Application for a Non-Material Amendment Following a Grant of Planning Permission

Erection of single storey side/rear extension.

77767/APP/2023/1355

Changes to fenestration of the rear extension element, reduction of roof form from pitched glass to flat roof with roof windows, and changes to internal layout.

Stage: Planning	Job Title: Single Storey Side & Rear Extension	Job Number: 12MC	Drawing Number: 03
	Client: Wafic Fawaz	Scale: 1 : 100 @ A3	Revision Suffix:
Drawing Title: Proposed Floor Plans	Site Address: 12 Marsworth Close, Hayes, UB4 9SZ	Date: 25/09/2023	Drawn By: GU
			Checked By: AA

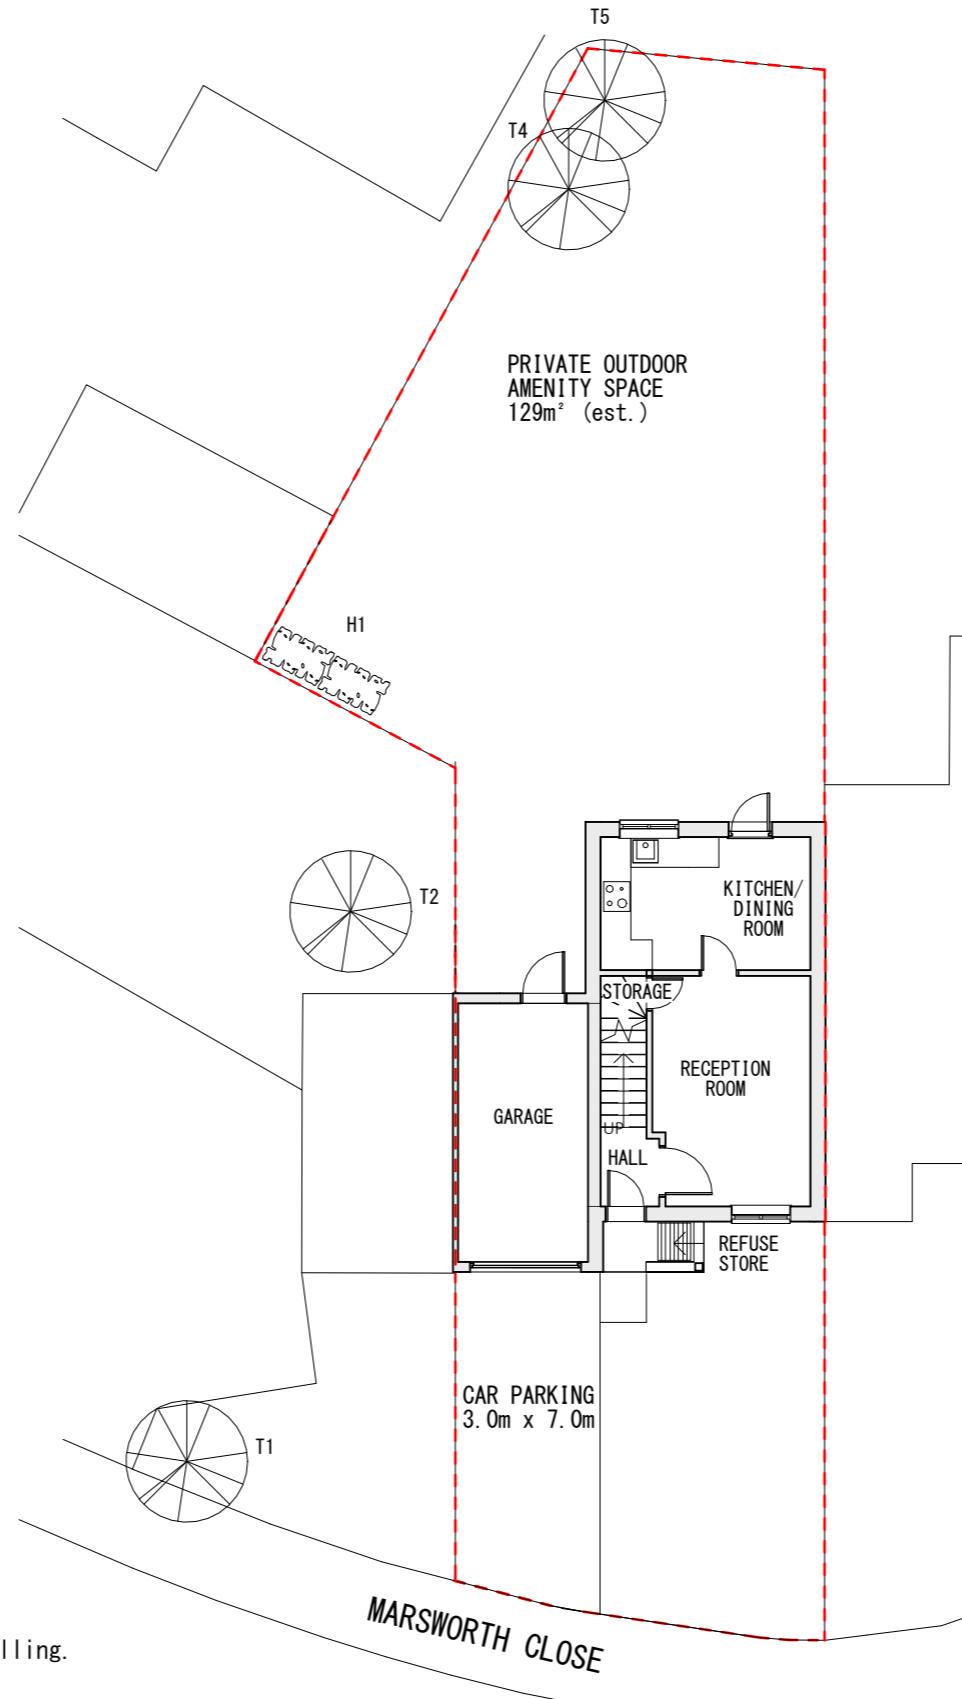
1. Obscured glaze along number 13 Marsworth to be replaced with bricks to prevent overlooking, daylight will be restricted due to existing boundary fence.
2. Pitched glass roof to be replaced with flat roof to match proposed side extension roof form and neighbouring extension roof form at number 11 Marsworth.
3. Introduction of 4 roof domes instead of entire roof being from glass like a conservatory.
4. Introduction of rear extension masonry columns of both sides of the patio doors to allow structural engineer to design suitable lintel(s) to support the patio door opening and roof structure.
5. Move proposed bathroom into previously proposed utility room, to create a larger living space in the proposed extension.
